TOWN AND COUNTRY PLANNING ACT 1990

Reference: H13-0847-20 **Date of Decision:** 11th December 2020
Applicant: Mr J Hook
The Anchor Inn
280 Bridge Road
Sutton Bridge
Spalding
PE12 9SH
Location: Rear Of 46 Seas End Road Moulton Seas End Spalding
Description: Erection of 2 detached dwellings

South Holland District Council hereby give notice that this application has been REFUSED for the above proposal for the following reason(s):

F	FLY TWO - MOE ANN VON BOWEN*				PET 2026
E	PLOT 2 TURNHEAD DRIVE				NV 2028
D	CLEINT AMENDMENTS				OCT 2024
C	PLANNING APPLICATION				JULY 2025
B	SITE PLANS & EXHIBITS				APRIL 2025
A	CLEINT AMENDMENTS				SEP 2026
REF.	REVISION				DATE

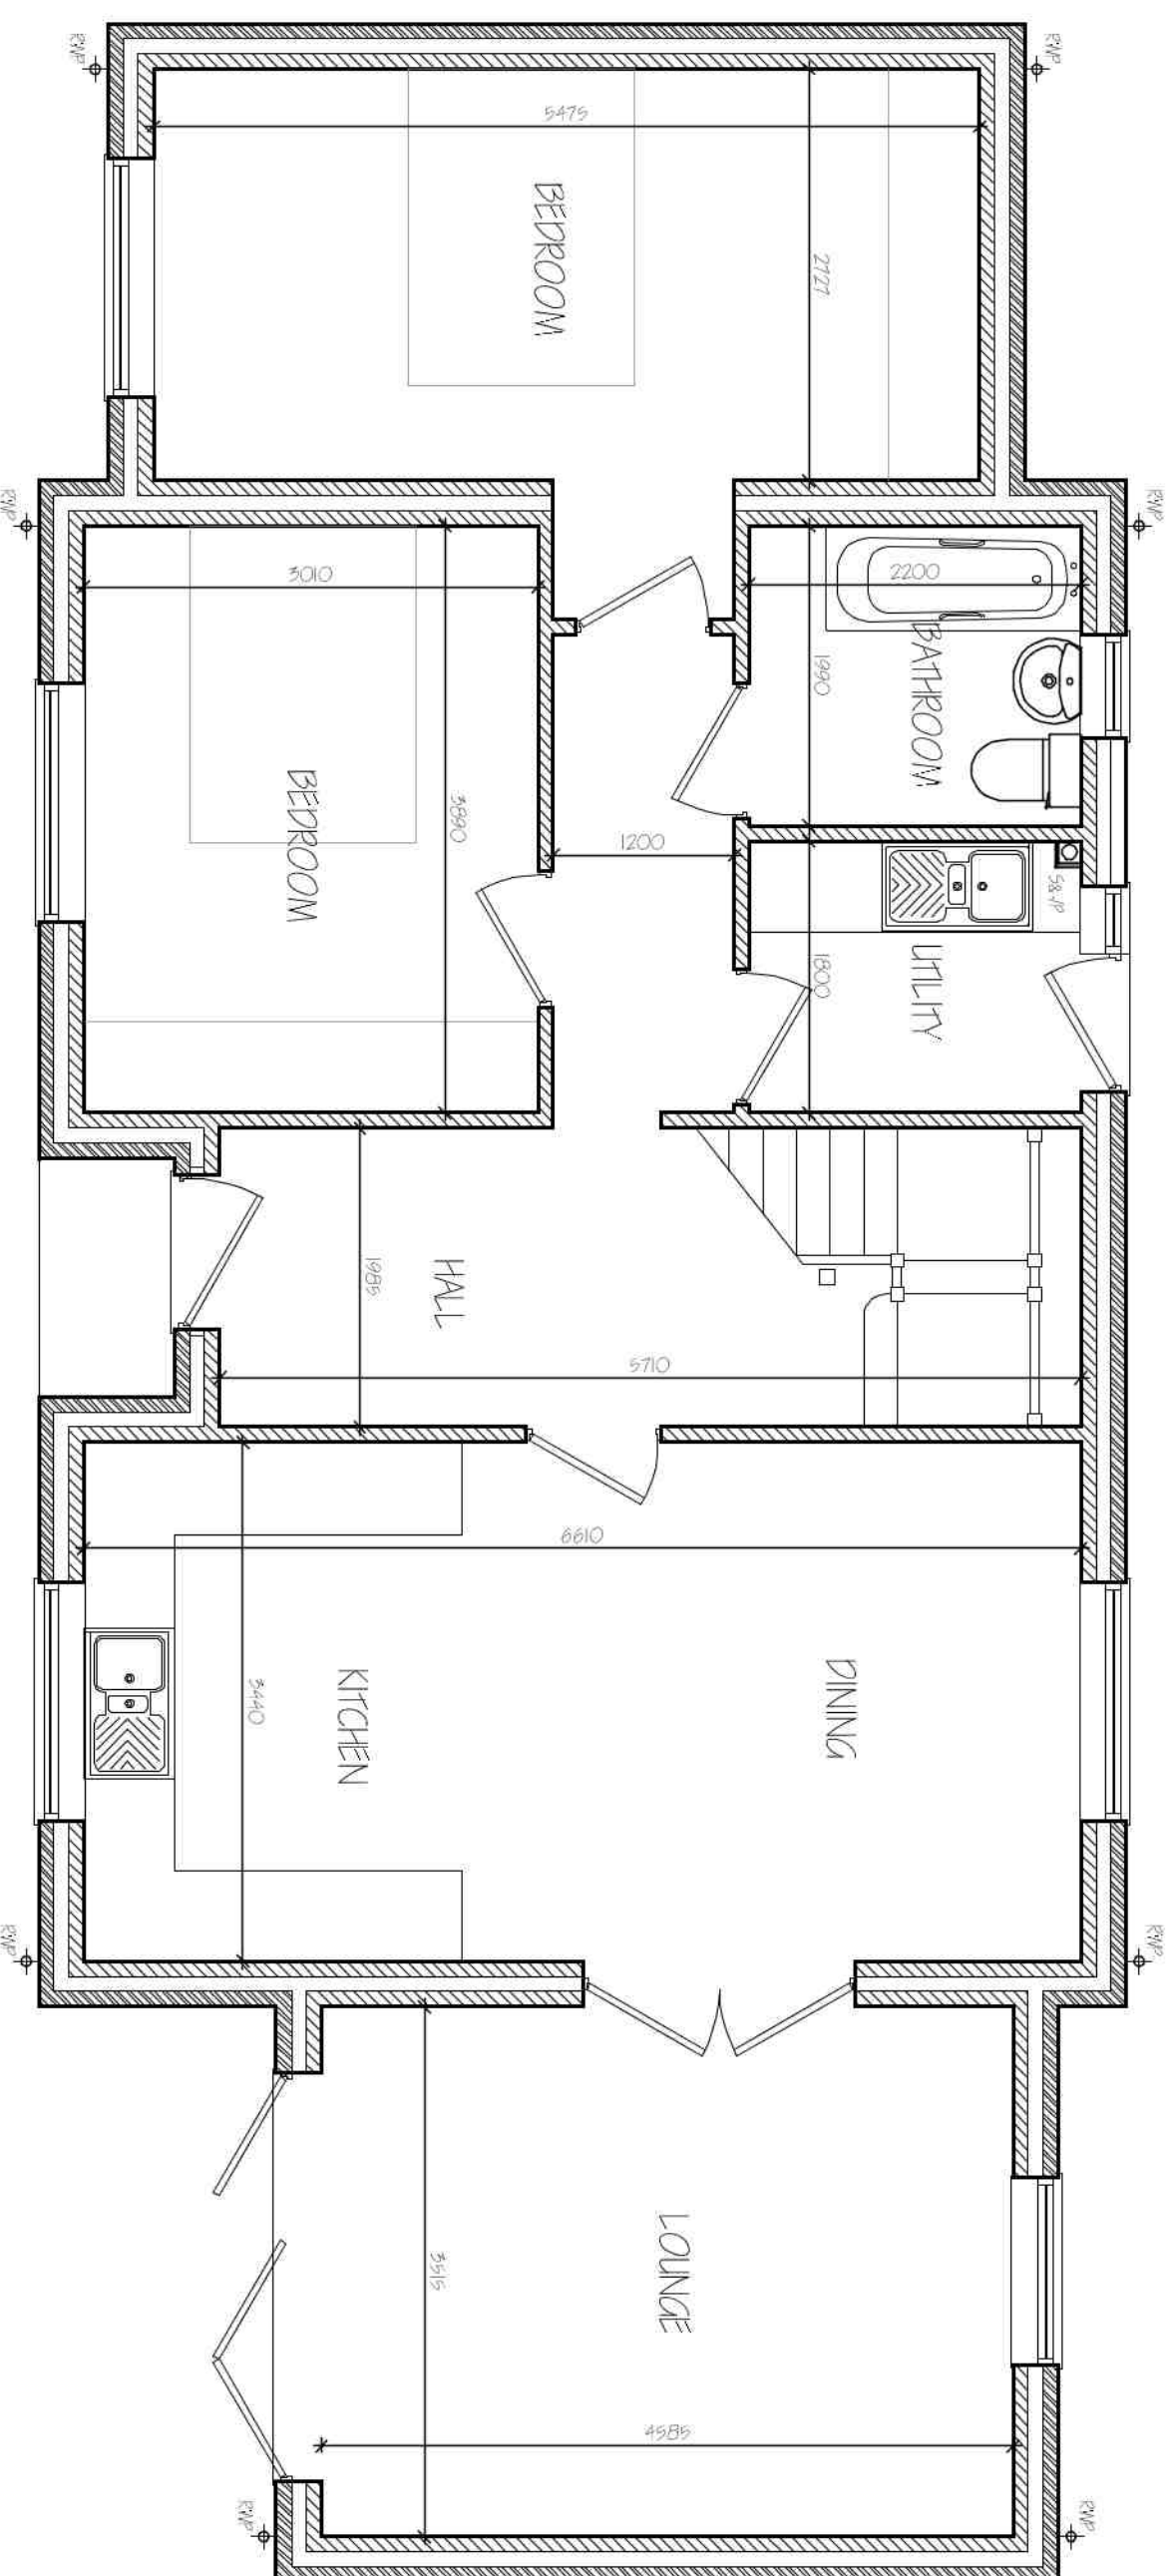
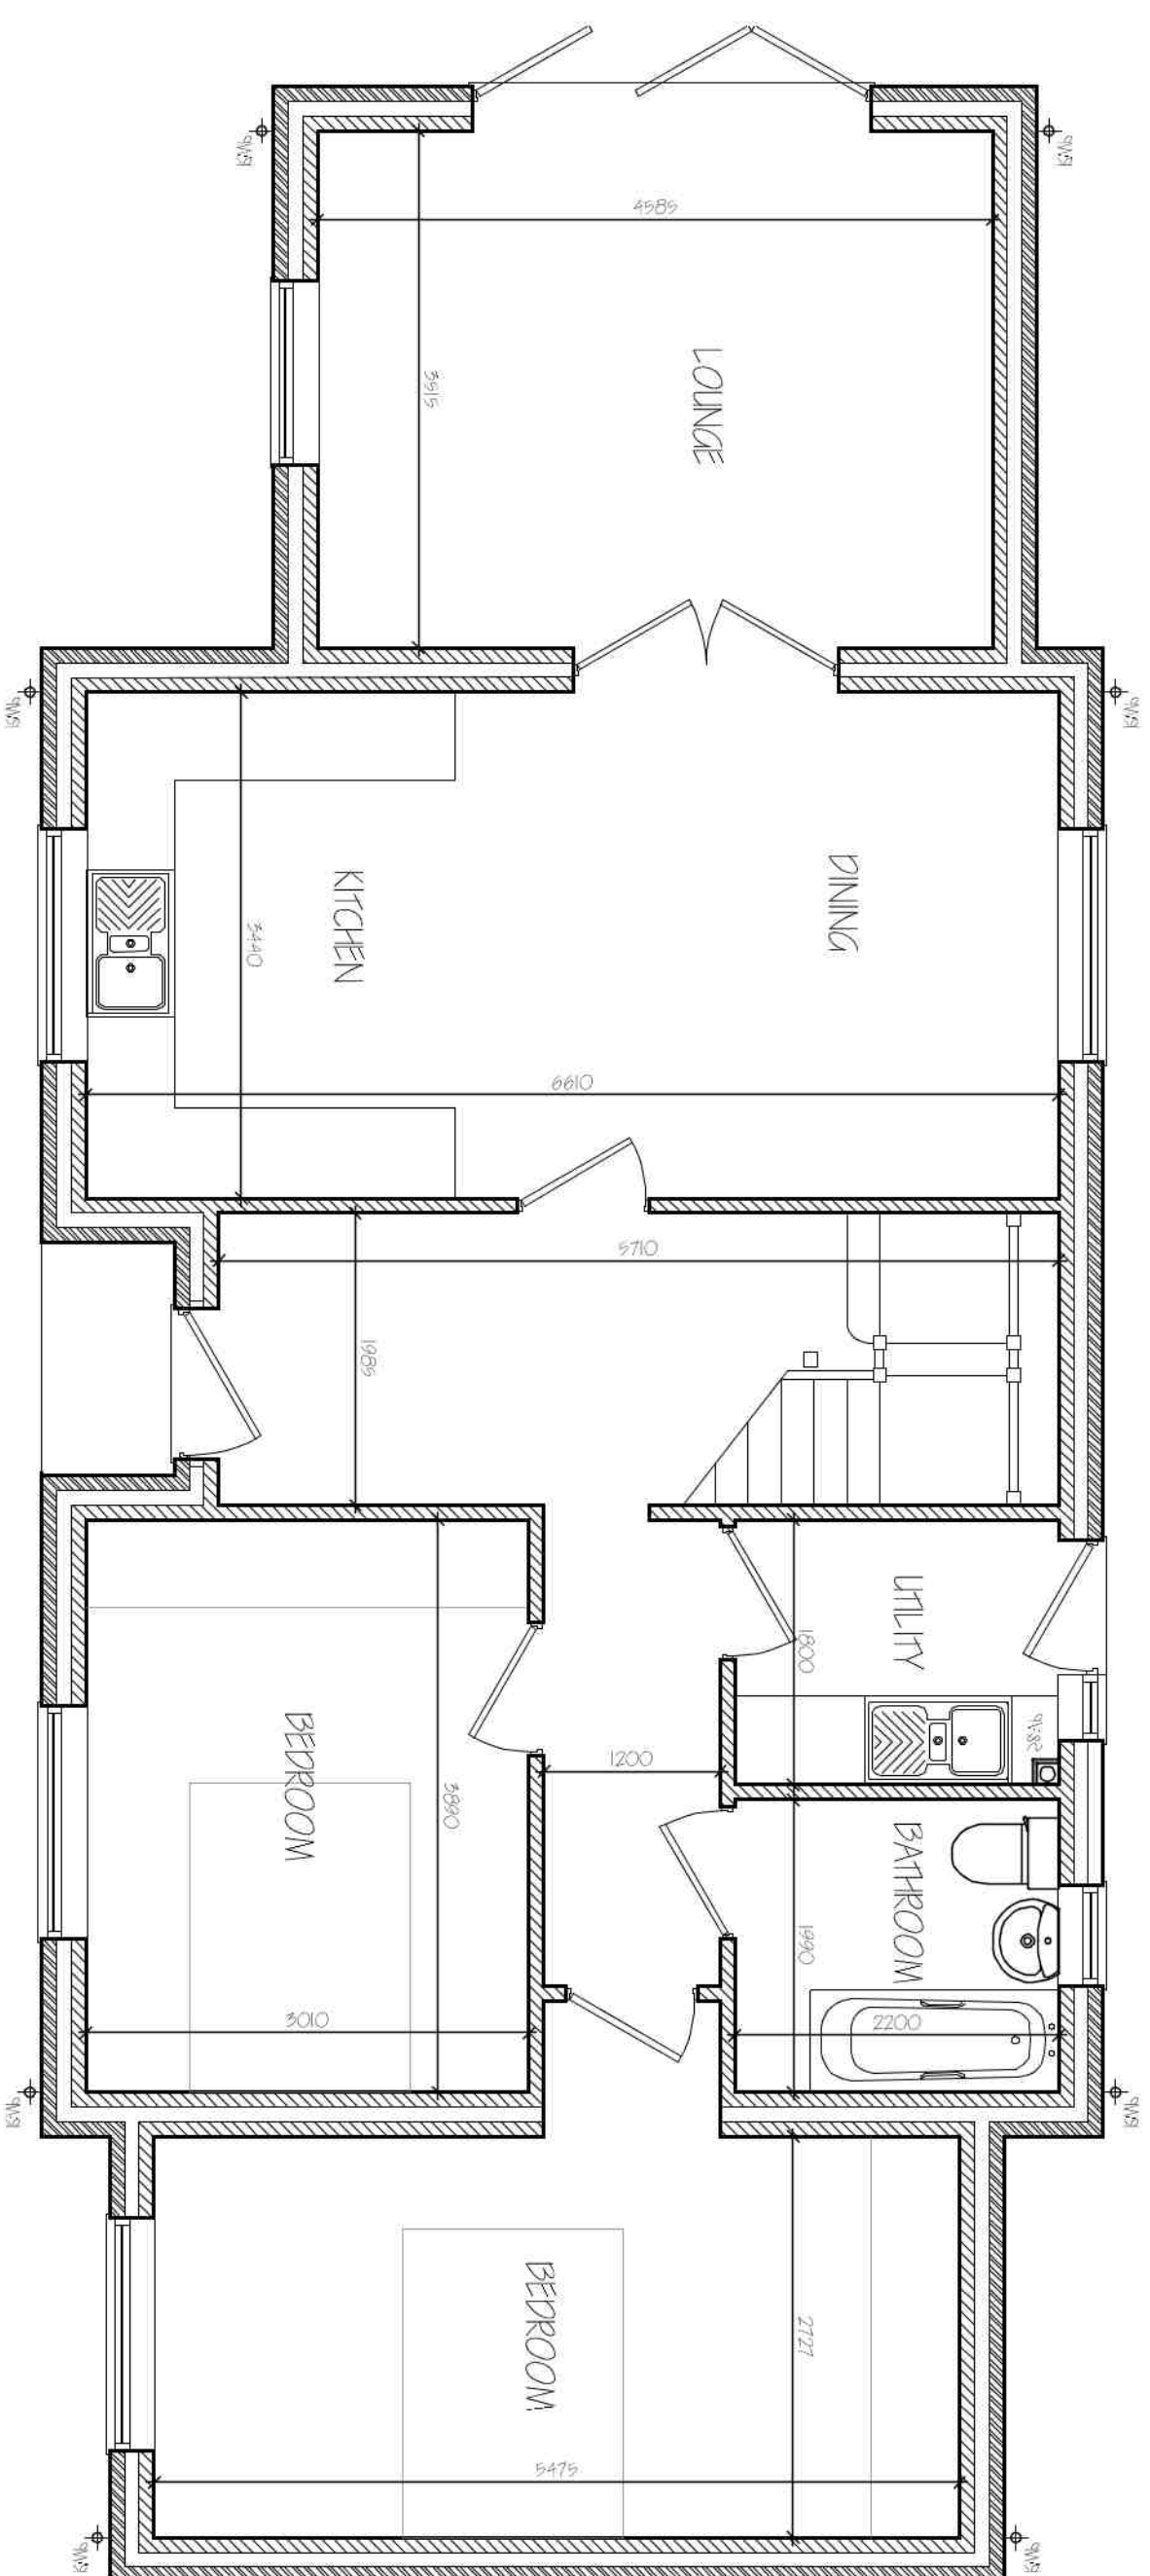
- 1 The scale of the proposed dwellings would result in a form of development that is visually cramped and dominated by building, hardstanding and boundary treatments (at the rear) and would negatively impact upon the character of the area.

- 2 Taking into account the separation distance between the rear elevation of Plot 2 and the rear elevation of no. 6 Hall Lane, it is considered that there will be a material adverse impact on the outlook of occupants from the rear.

Furthermore, there are also issues of overlooking as well as minimal and seemingly unfunctional areas of external amenity space attributed to Plot 2.
